ENG-PUDSP20005-R1-PDR-redlines.pdf Markup Summary

## PROPOSED DRAINAGE MAP

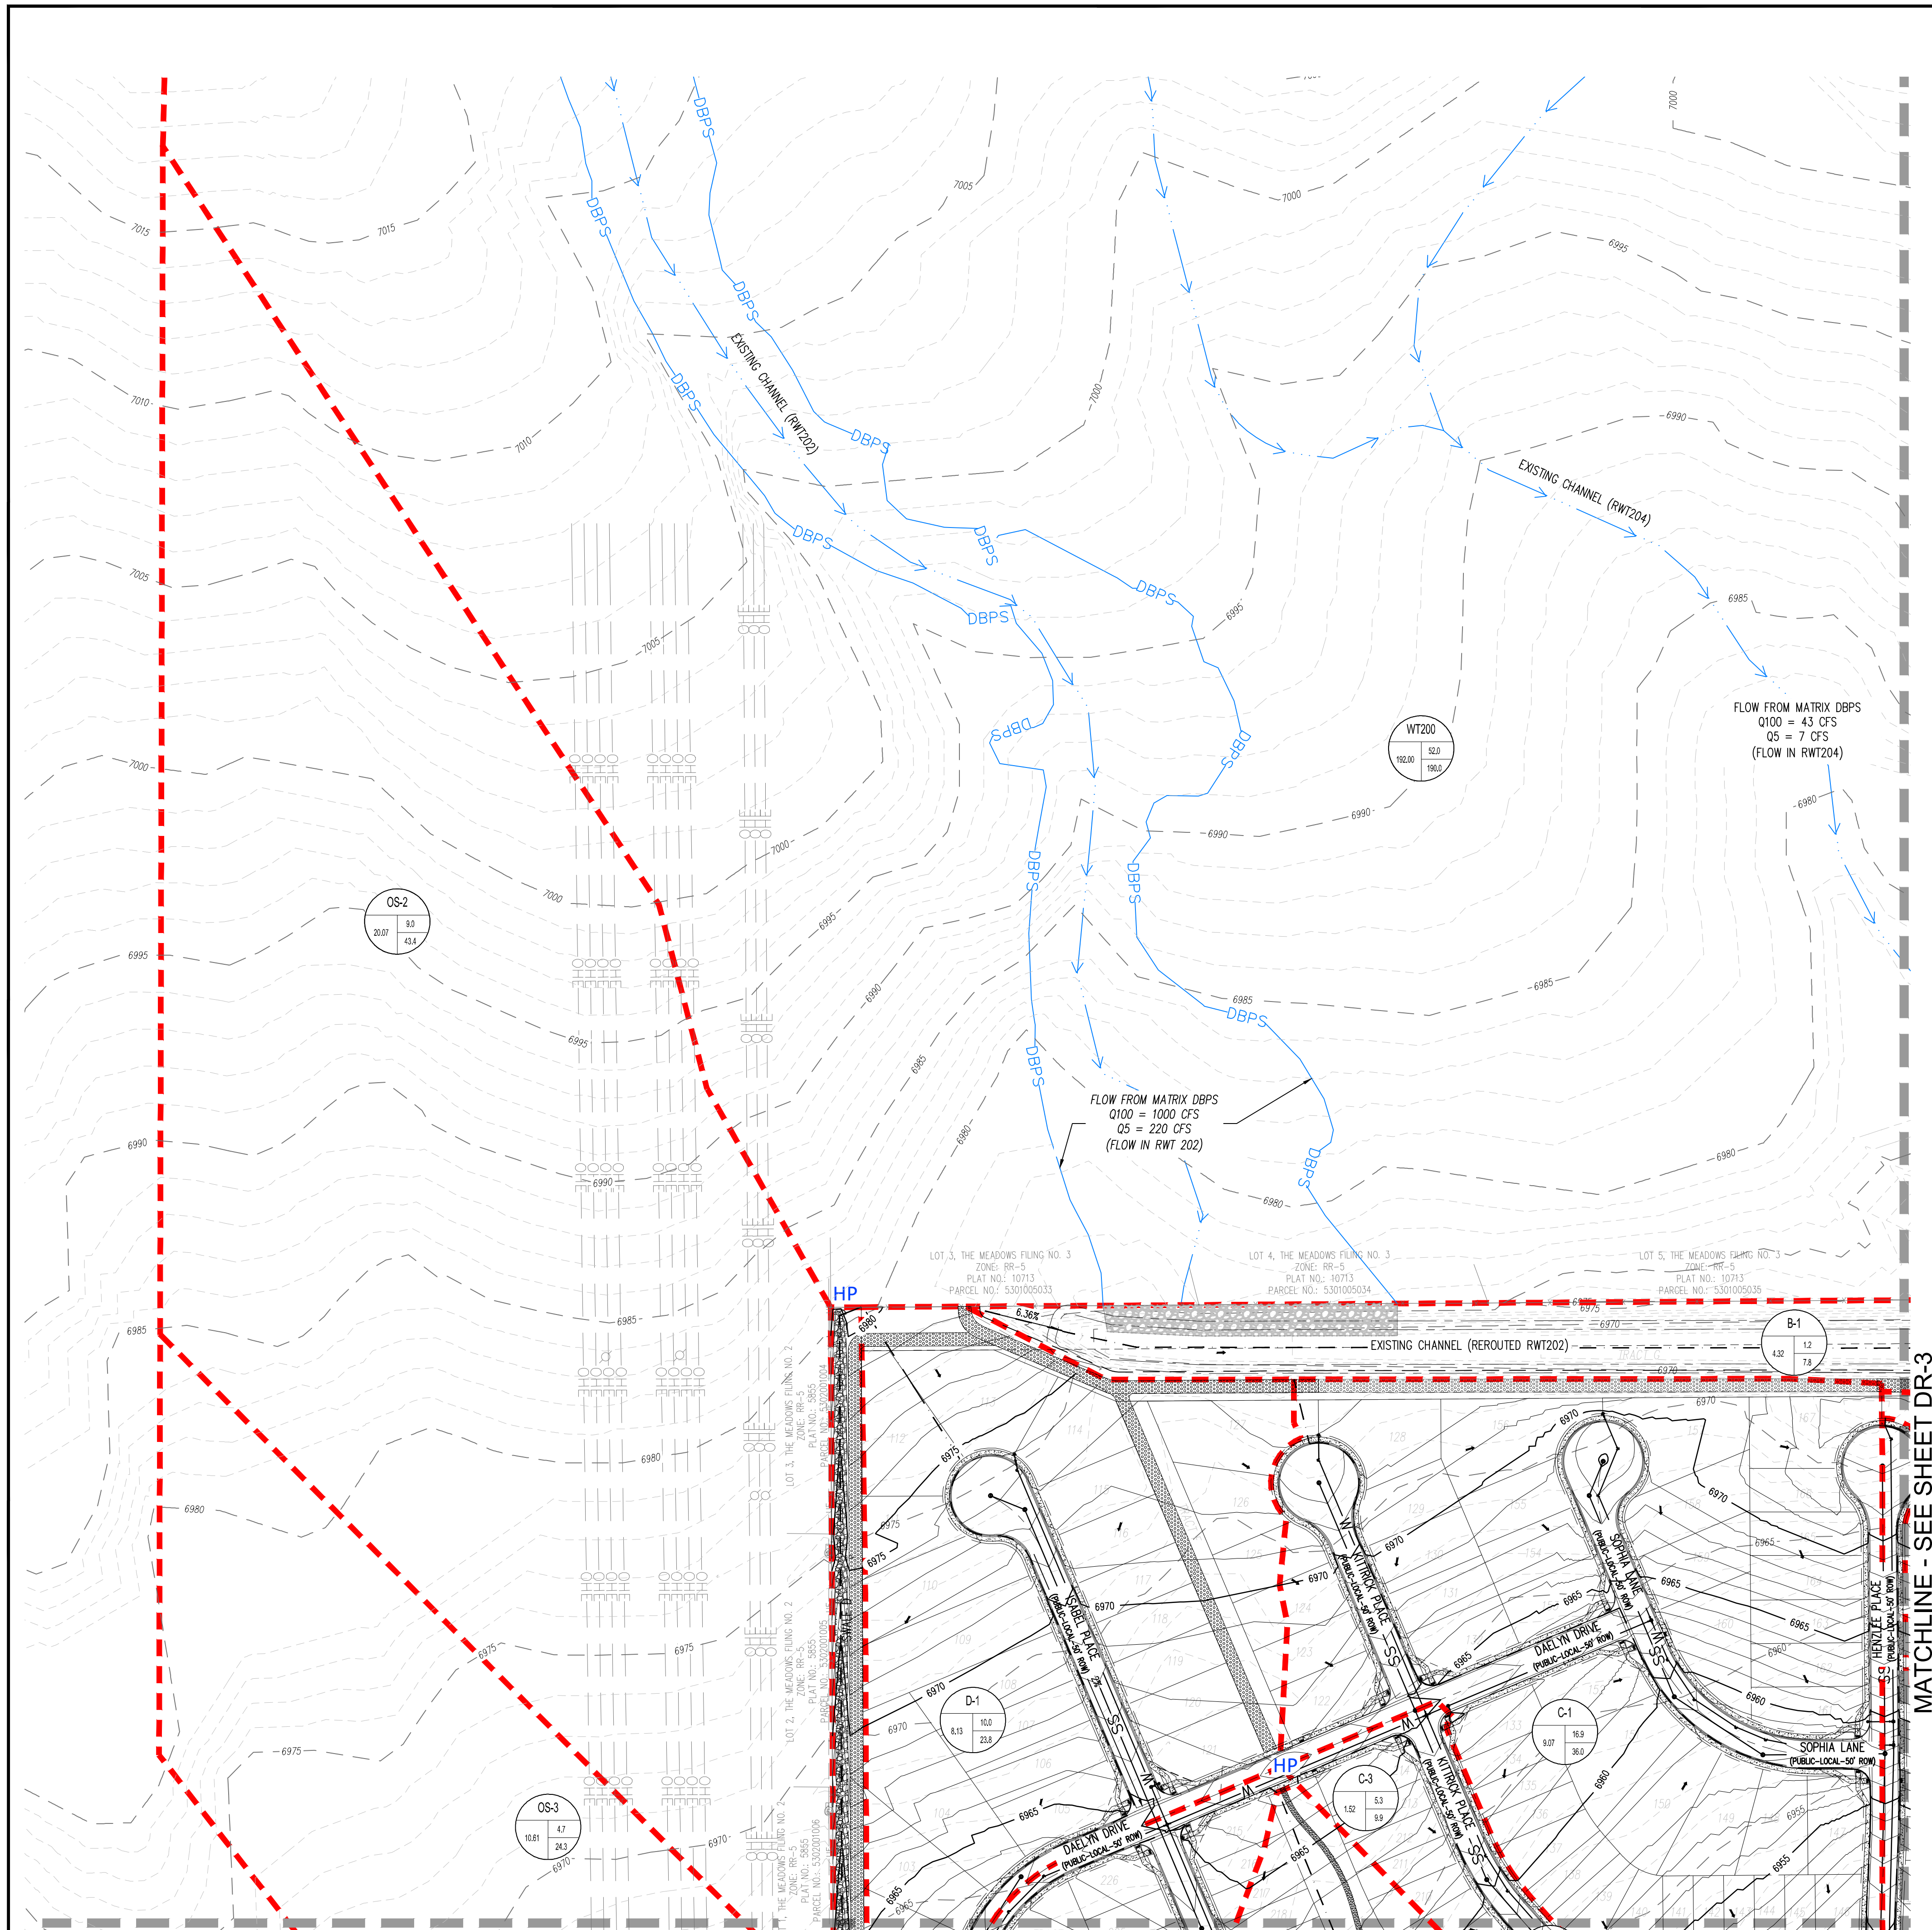
DP 9?

DR-4

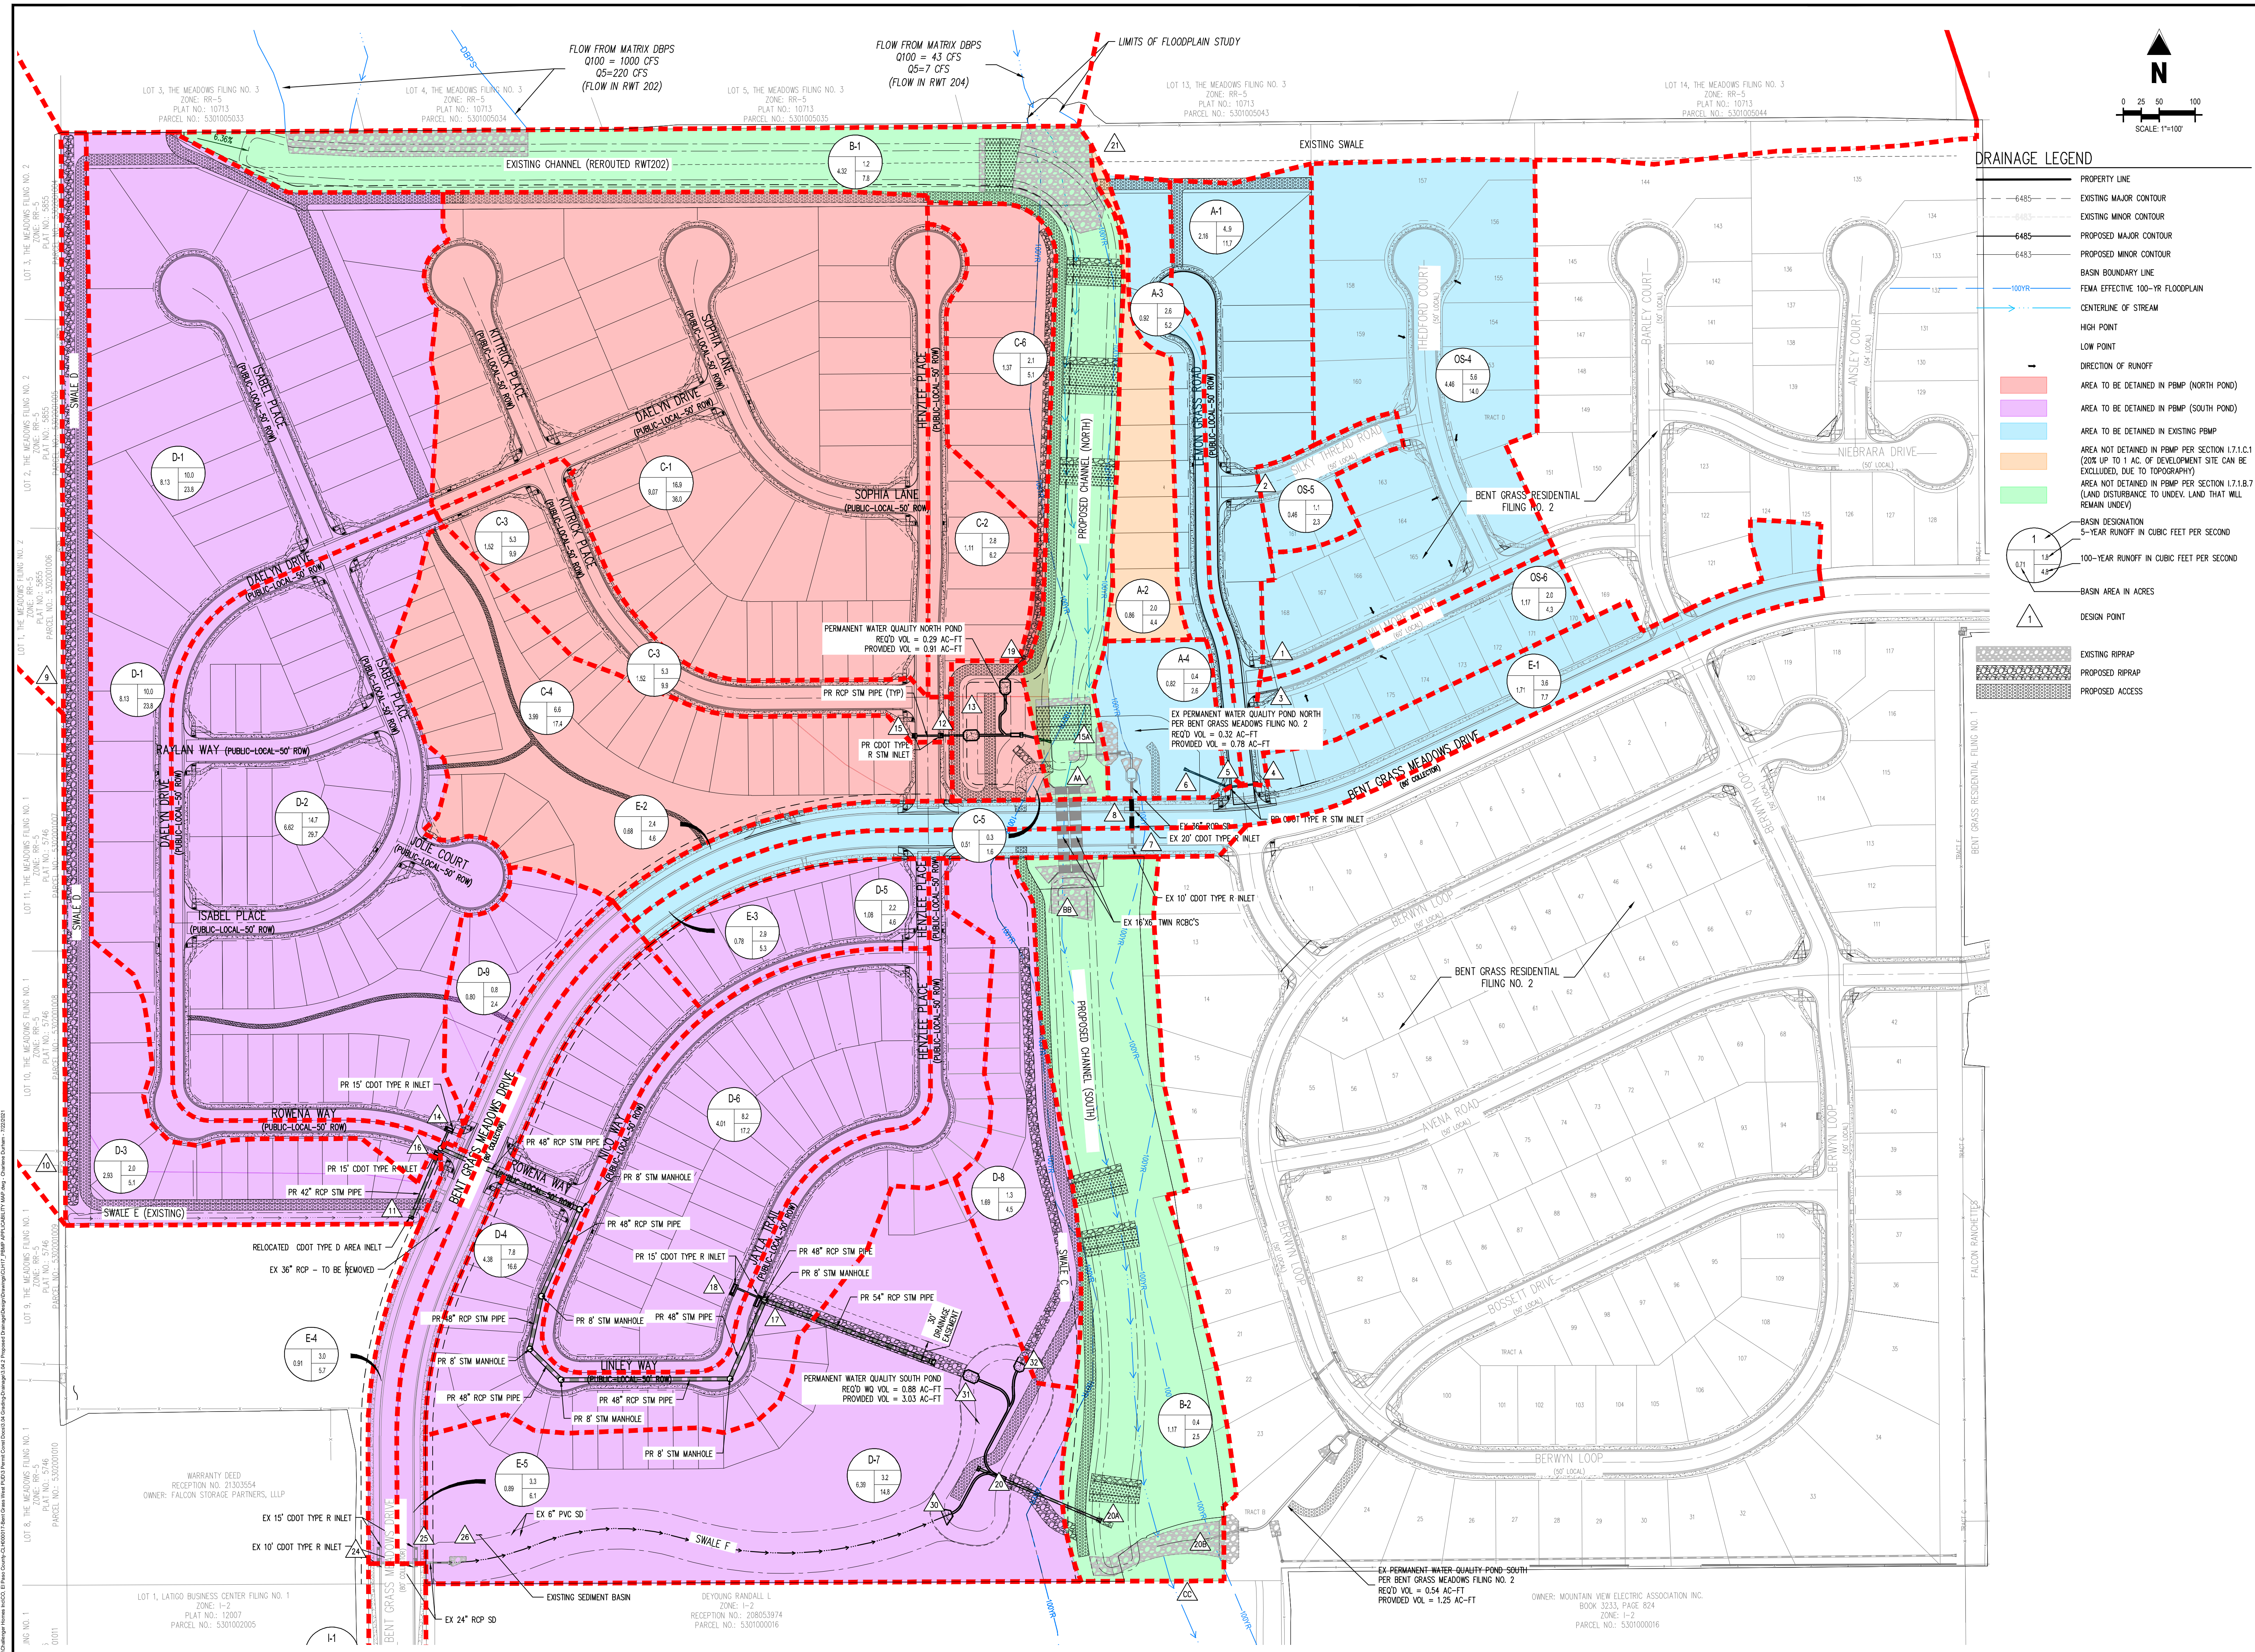
Provide a DP for flows from the west in the road

Provide a DP for total existing flows

Label channel flows

label improvements

backwards?

If these are only site flows, provide a note stating that.

Label total developed channel flows

provide size

Show spillway location and design.
